Response to Canal + River Trust comments - 09th July 2026

We have received the following comments from Canal + River Trust Spatial Planning Team in respects of planning application 2026/90387 at Upper Mills, Canal Side, Slaithwaite, Huddersfield, HD7 5HA.

PROJECT TITLE IGLU SLAITHWAITE, HD7 5AH		
DRAWING TITLE PROPOSED SECTION AA		
DATE 05.09.2025	DRAWN JH	SCALE 1:50 + 100
PROJECT P0097	NUMBER P_AS_AA	REVISION 04

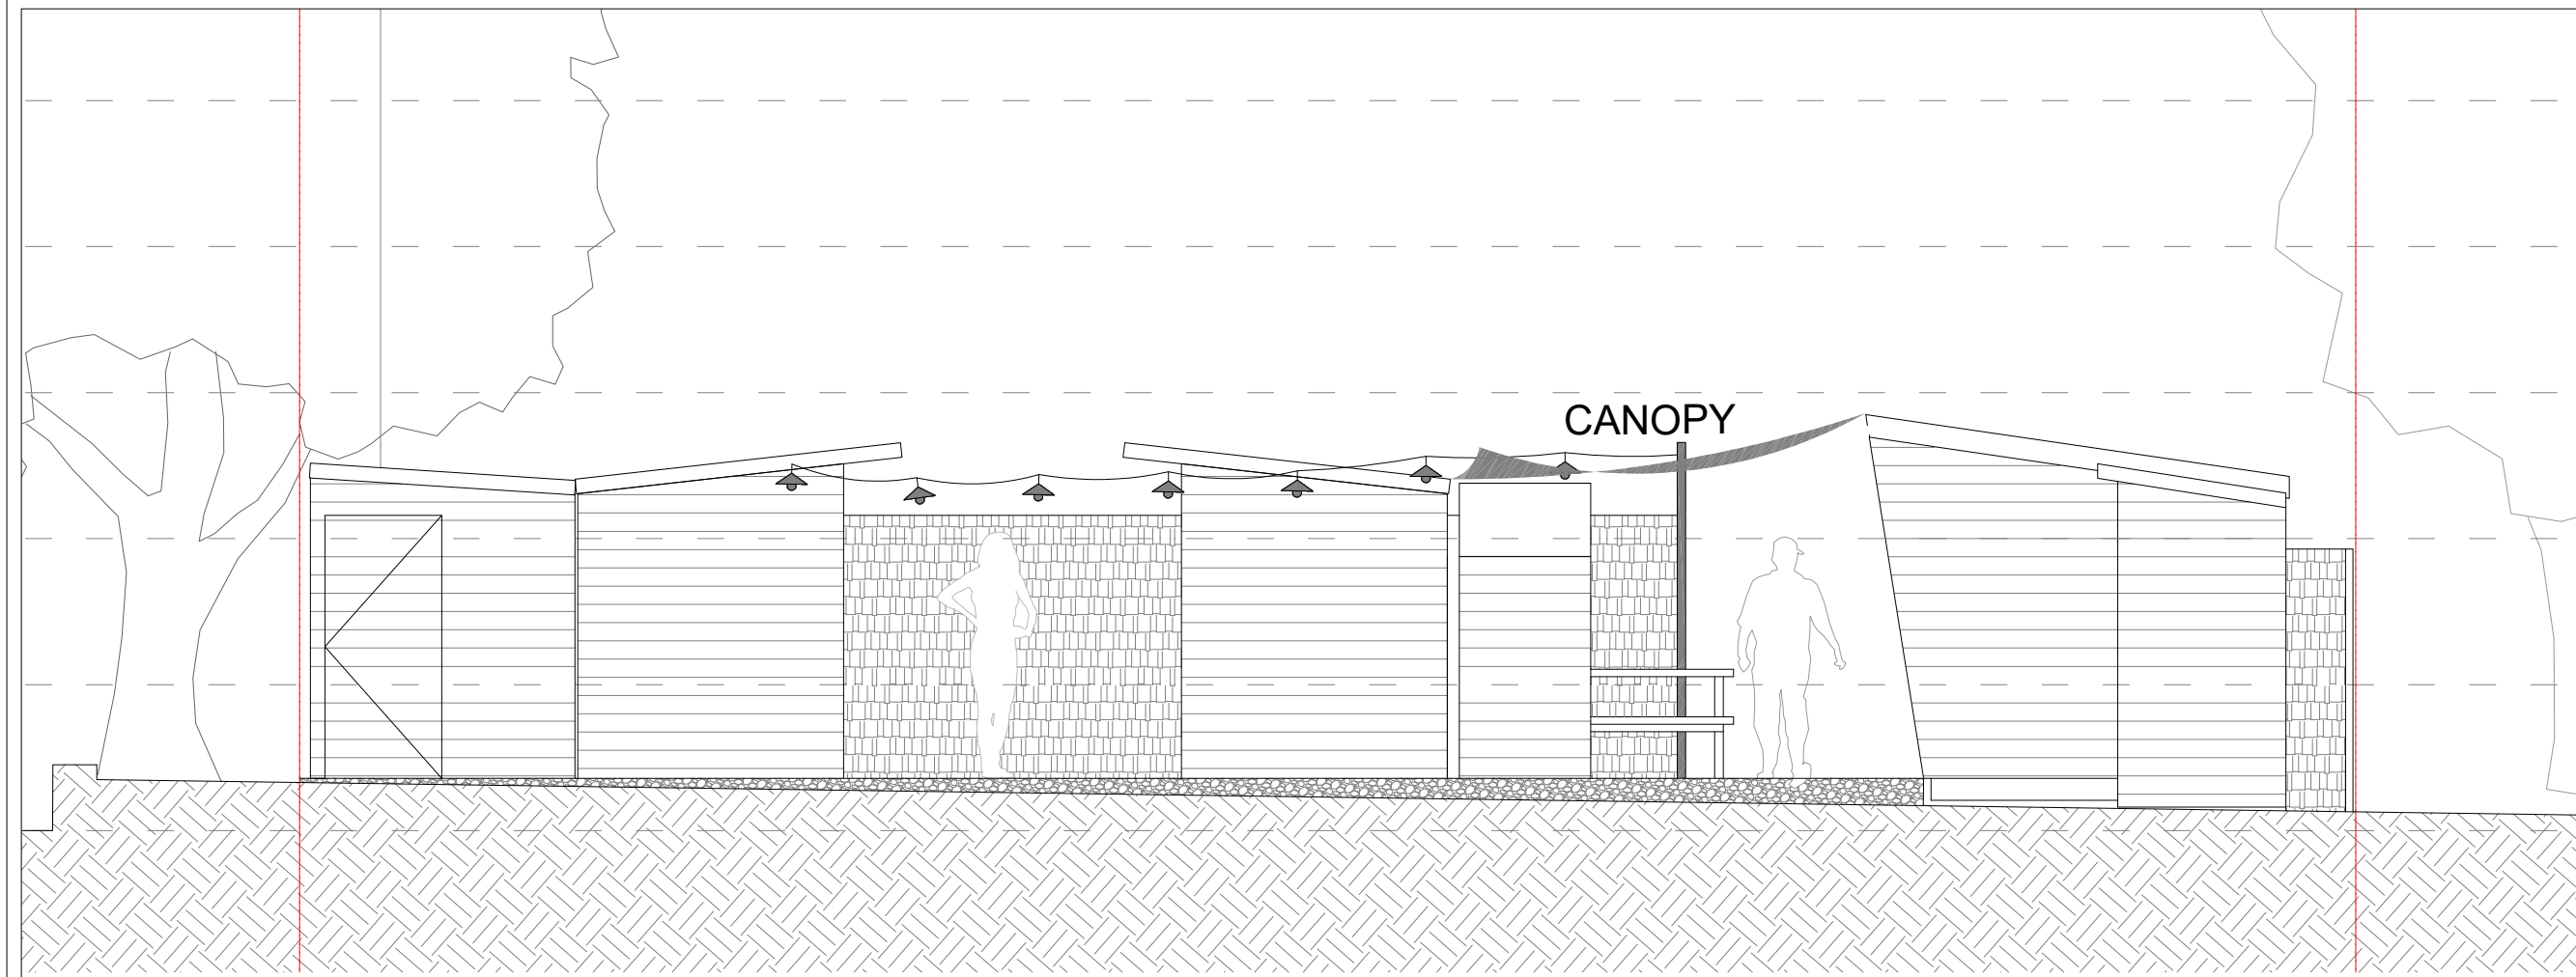
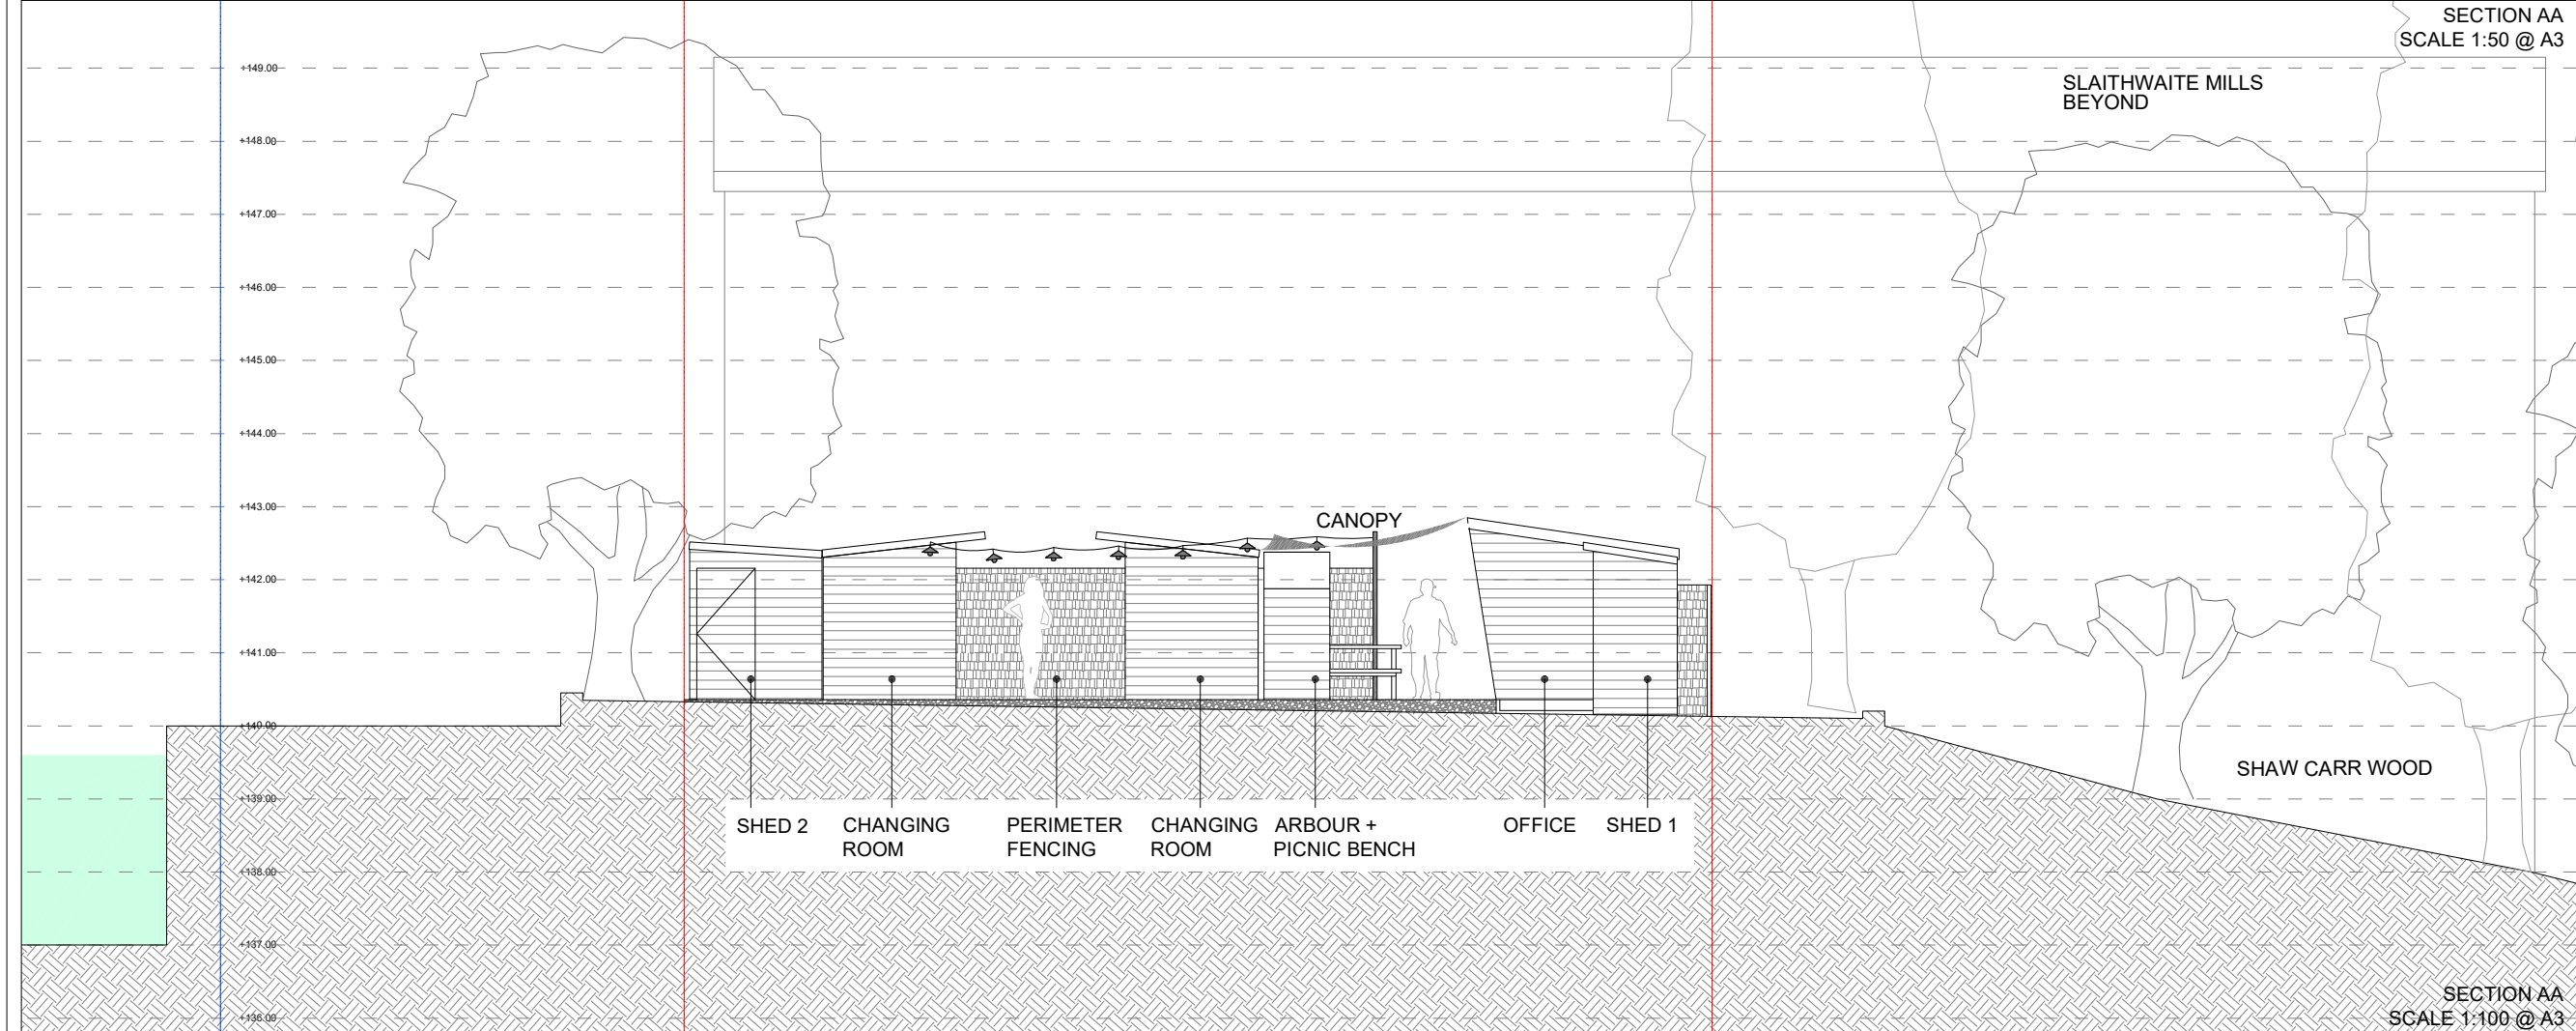
"We request that details of the management of surface water should be provided in order to ensure that it will be appropriately managed and will not result in unmanaged water discharge to the canal or watercourses that interact with the canal."

The site is surfaced with permeable, free-draining materials, allowing rainfall to infiltrate into the ground. The site's topography is generally level, with a gradual fall towards the former mill dam and the River, rather than towards the canal. It is understood that, prior to the land becoming disused, this area formed part of the historic mill dam.

Section A-A illustrates the approximate relationship in levels between the canal on the left of the image, the application site and the River on the right, demonstrating that surface water does not naturally drain towards the canal.

FLOOR PLAN
SCALE 1:100 @ A3

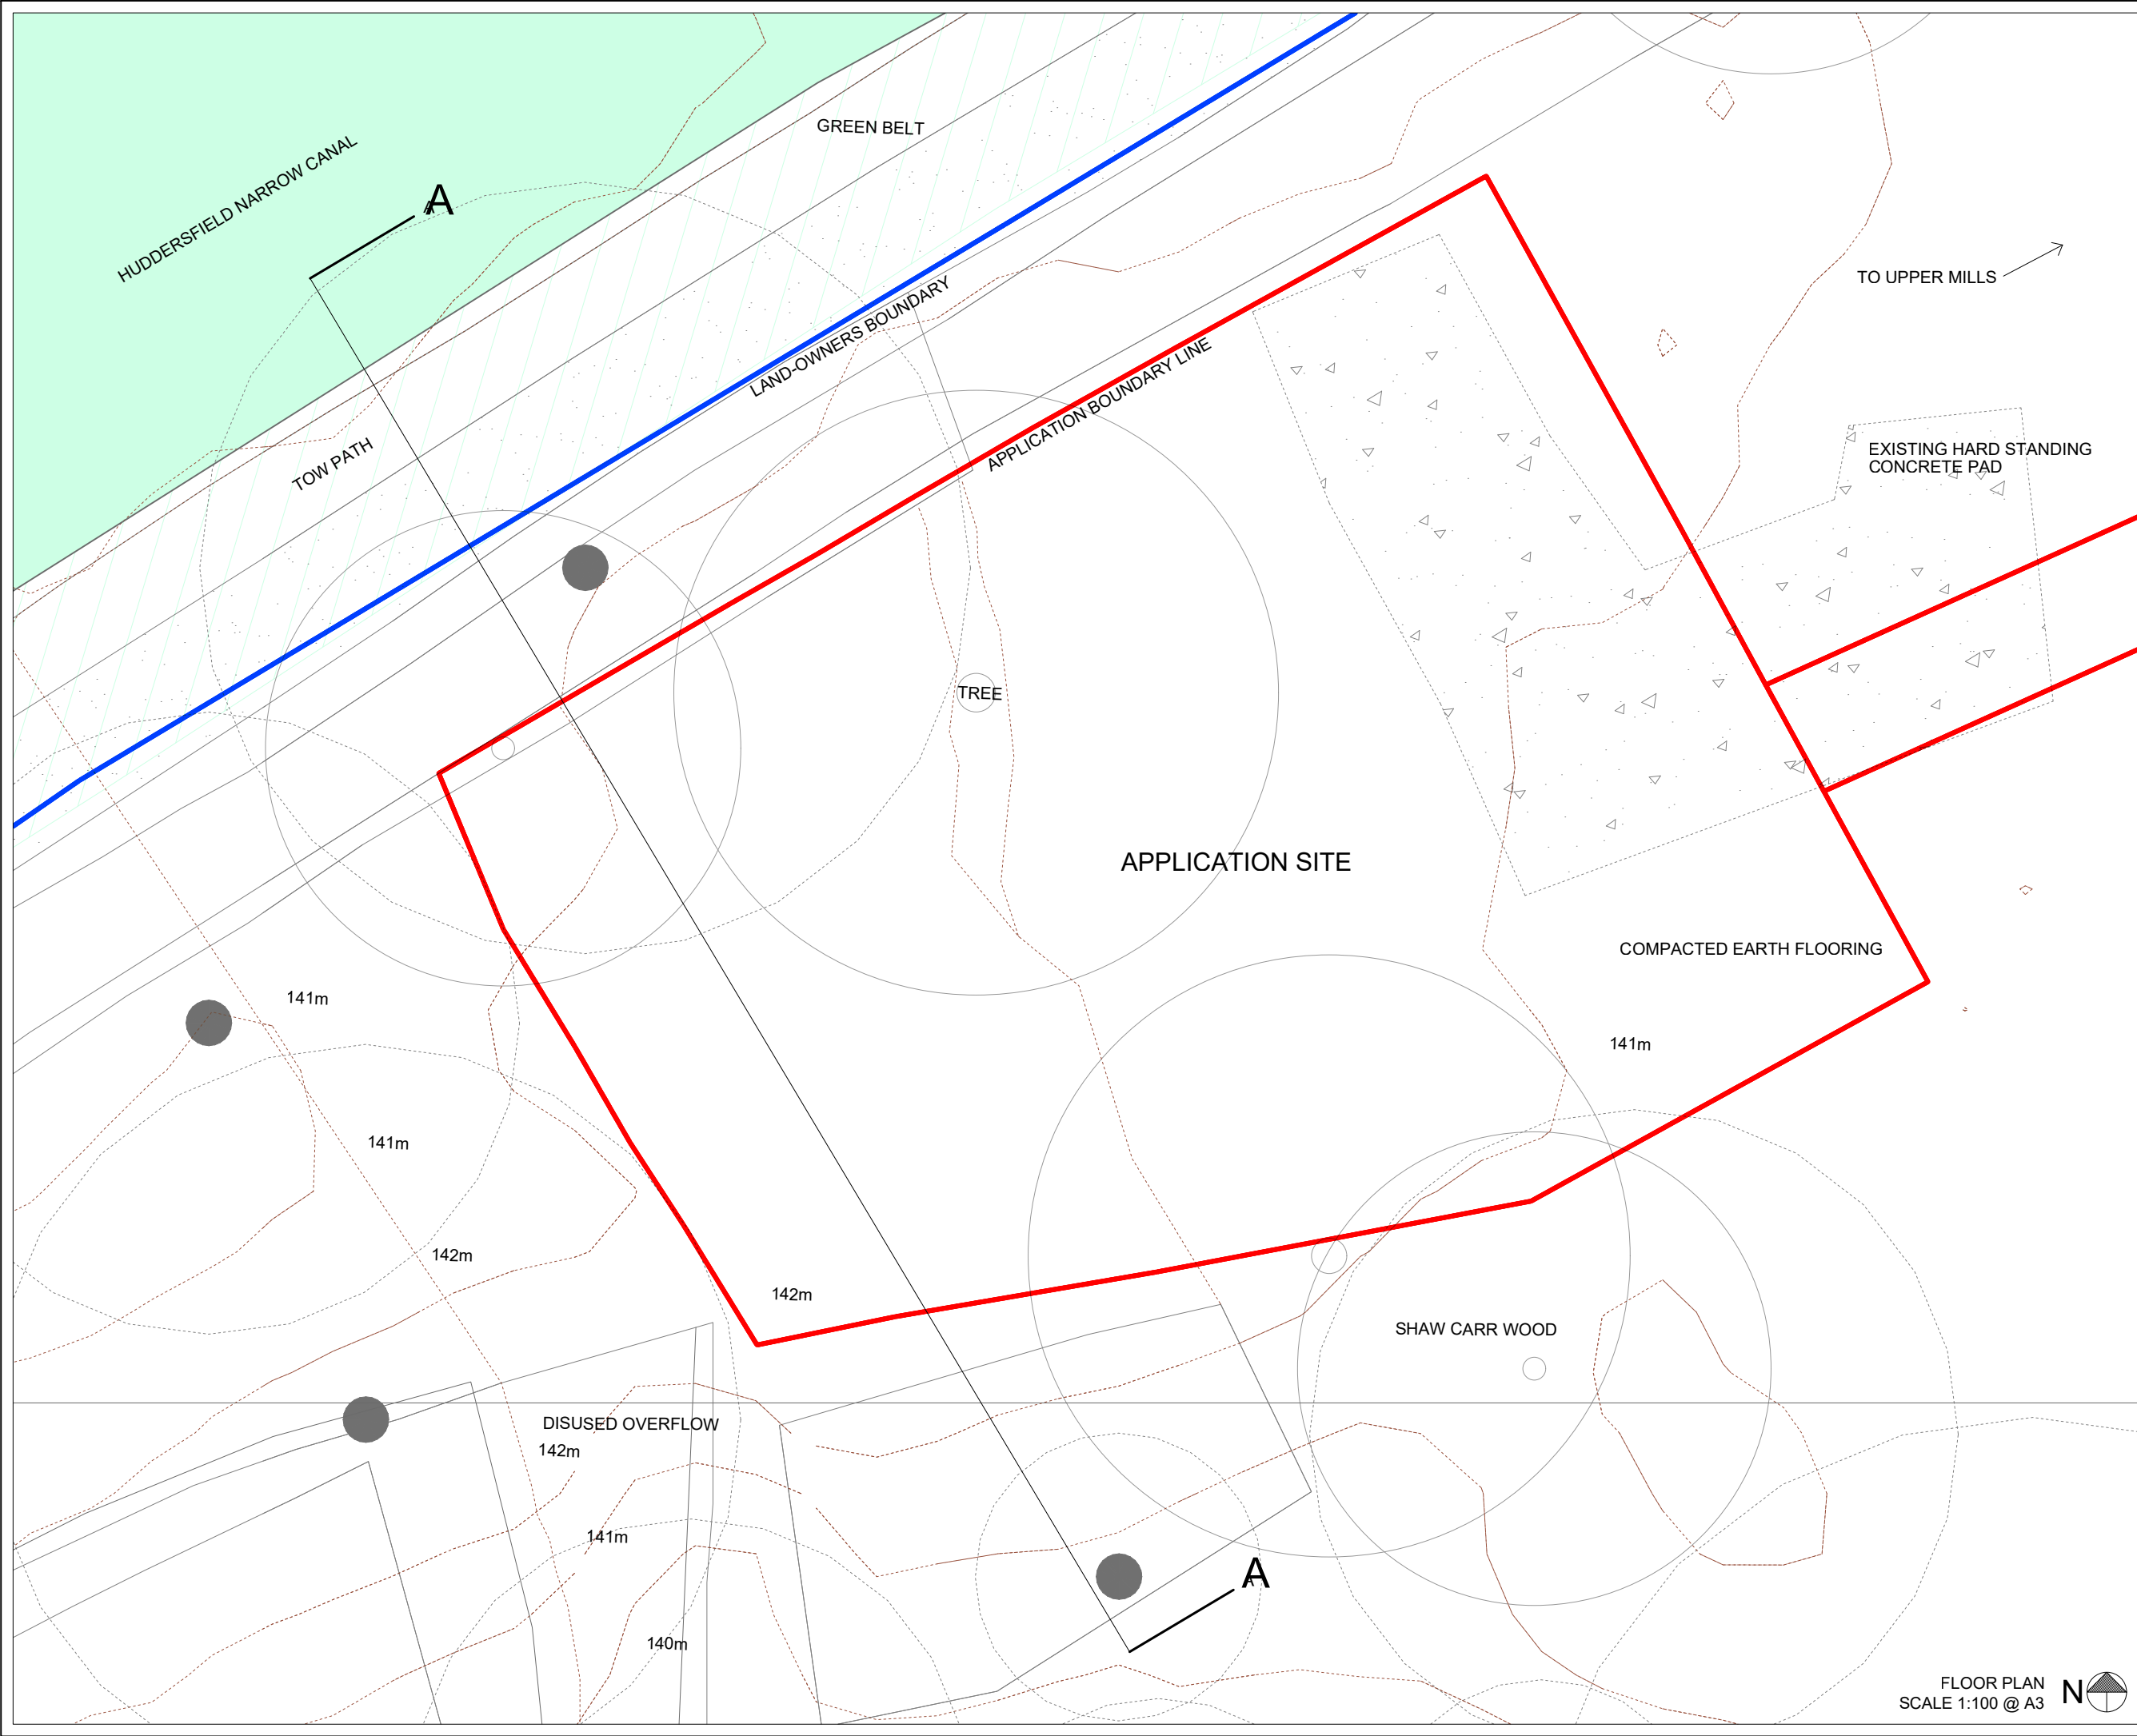
"In addition to the above, we request that confirmation should be received as to where water from plunge pools on site will be disposed to. We assume this will be to the sewer network. However, if alternative means of disposal are sought, then details of the management of this should be received due to the potential high levels of chlorine used."

The locations of the plunge pools and showers are identified on the plan above.

The plunge pools are plumbed from the rear (as shown in Photo 2), with drainage provided through the visible rigid and flexible pipework directly into the existing mains sewer network. Grey water from the plunge pools, showers and staff sink will all discharge to the site's existing combined mains drainage system.

Users are encouraged to shower before and after using the plunge pools. Wastewater from the showers is collected beneath the shower platform and directed into the existing mains drainage serving the mill, as shown on the submitted plans.
